RE: 4346 E. Mercer Way, Critical Area Determination (CAO17-003)

Please find attached the 3rd revised Critical Area Study and Watercourse and Wetland Buffer Reduction Report for CAO17-003 originally submitted on March 8, 2017, revised on March 24, 2018, and revised on June 8, 2018.

ESA/City of MI Comments	Response
<p>1. The shoreline management requirements are separate from the wetland and stream buffer reduction requirements so the area within 20 feet of the Ordinary High Water Mark should not be included in the wetland and stream buffer calculations consistent with MICC 19.07.110(9)(d)(i). These areas shall be removed from the mitigation ratio calculations for buffer reduction.</p>	<p>Sheet 2 of 5 in the Critical Areas Study submitted on June 8, 2018 lists the mitigation enhancement area and ratio outside of the area 20 feet from the OHWM. The ratio is listed at 31:1, and 5,896 square feet, for the area more than 20 feet from the OHWM. Both information is shown, as the city previously stated the area must be planted, per the SMP. This is to ensure there is no confusion in future permits, such as the building permit. Further, we have updated the sheet to use a different key for

SCALE: 1"=5'
 SHEET: 4 of 5

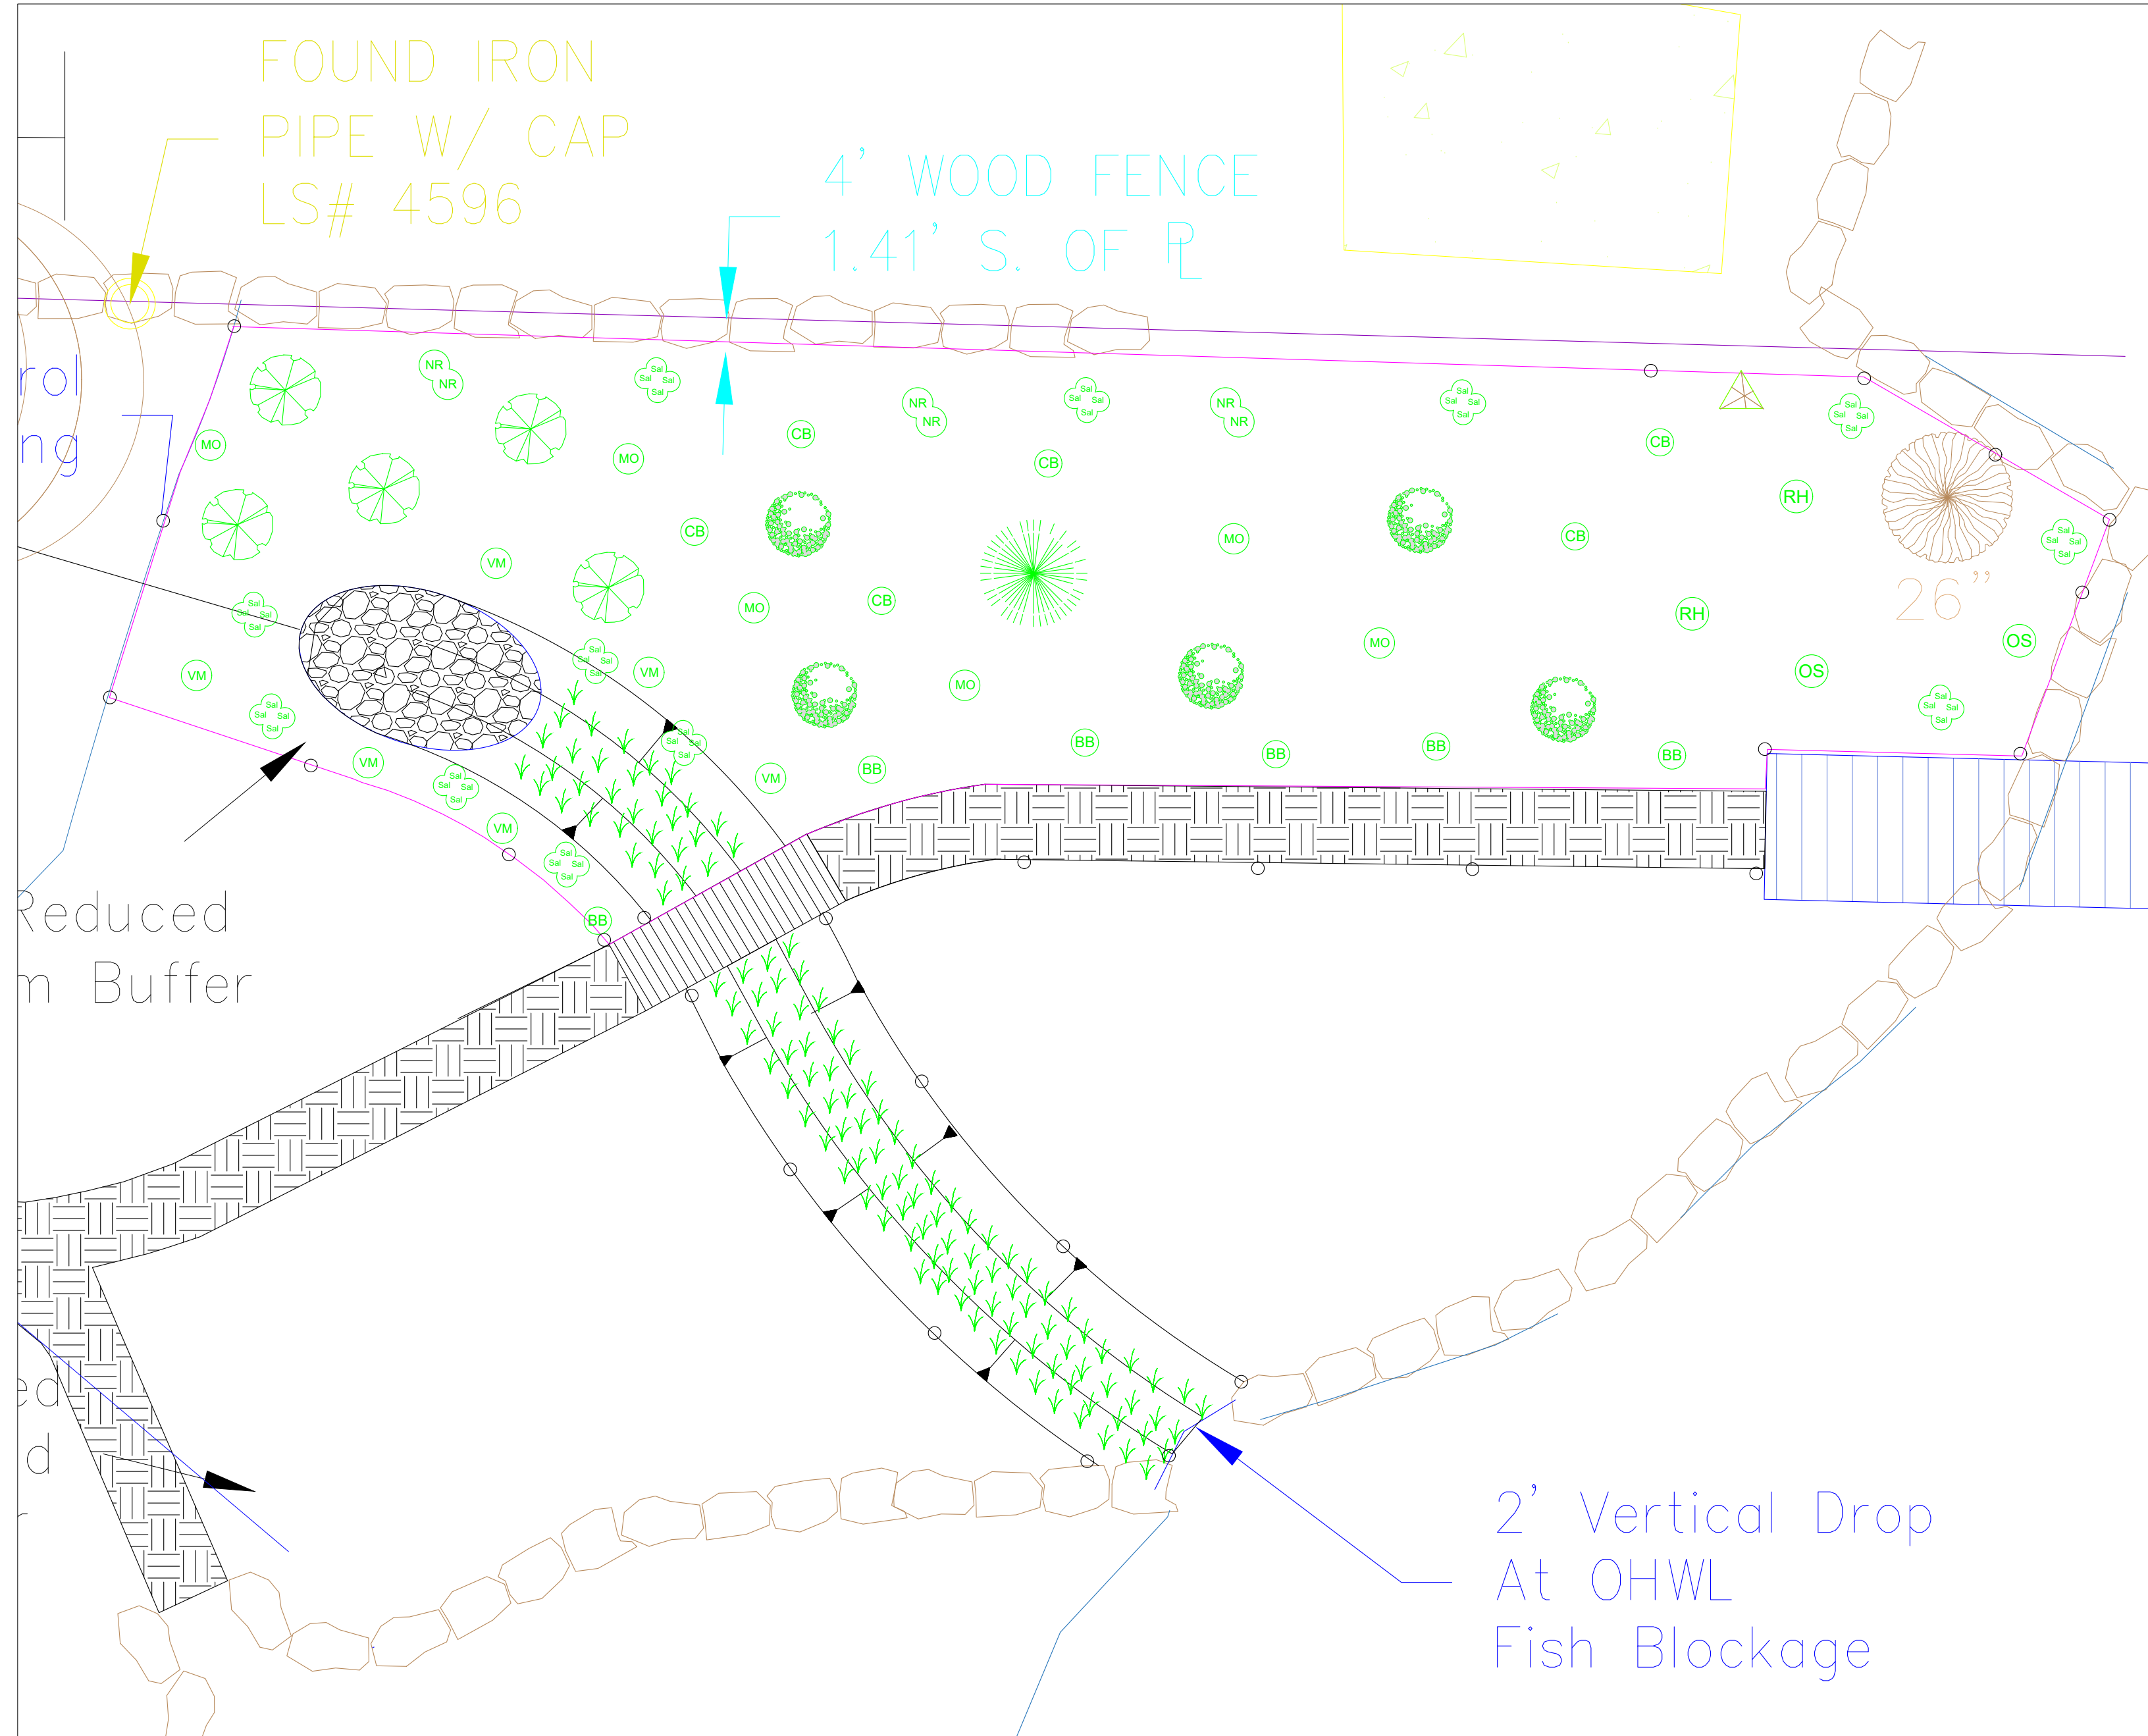
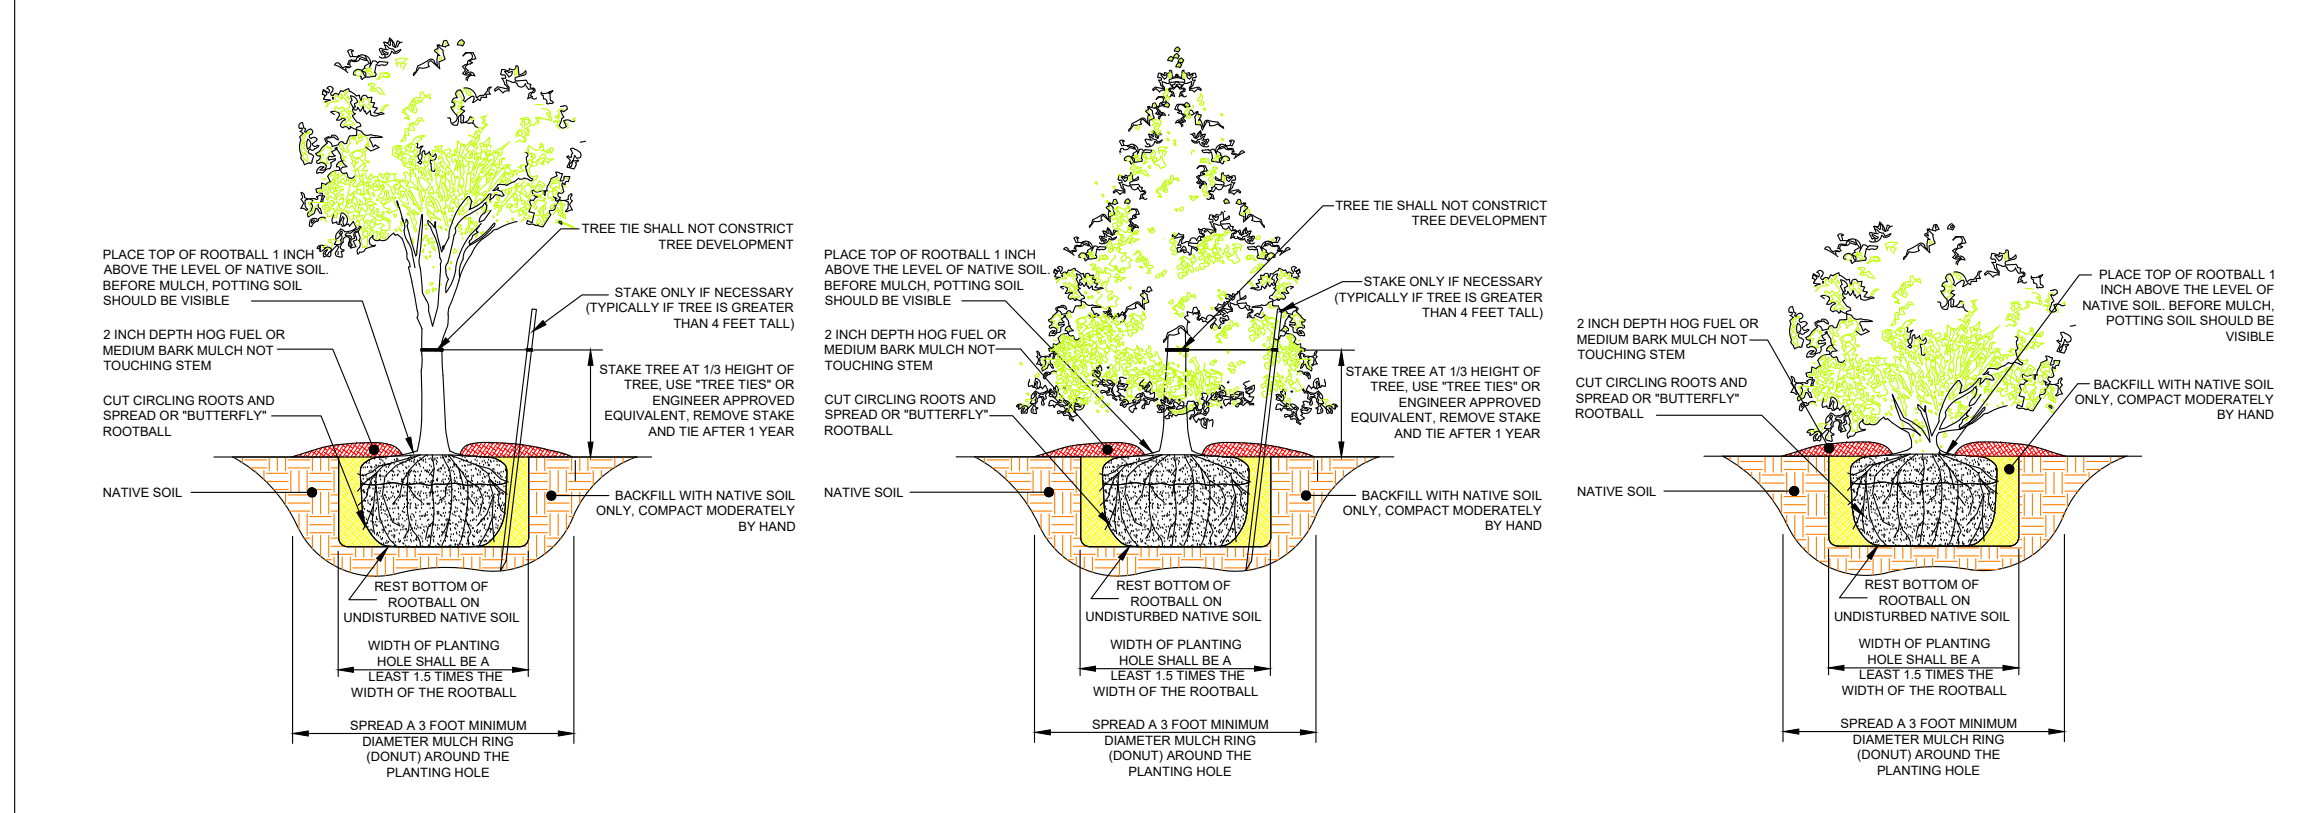
<p>4. Please provide additional detailed information for the proposed fish blockage removal. Provide the total area of excavation and grading within the stream, the proposed construction sequencing, the engineering design versus conceptual plan, and a statement that the remaining rocks in the stream channel will not block fish passage or removal of the remaining rocks.</p>	<p>a. The total area of excavation and grading of the watercourse has been added to Sheet 4 of 5. b. The details of construction sequencing has been added to Sheet 4 of 5. c. More detailed design has been added to sheet 4 of 5. d. The following statement has been added to Sheet 4 of 5:</p>

<i>The remaining rocks in the stream channel will not block fish passage, nor will removal of the remaining rocks.</i>
5. Given the location of the stream mouth at the transition from the hard stabilization structure and beach, please use soft shoreline stabilization for the shoreline structural stabilization proposed in Details 4.2a and 4.2b of the Buffer Reduction Mitigation Plan.	See above response 4c) where cedar logs have been chosen in the detailed design as soft shoreline stabilization.
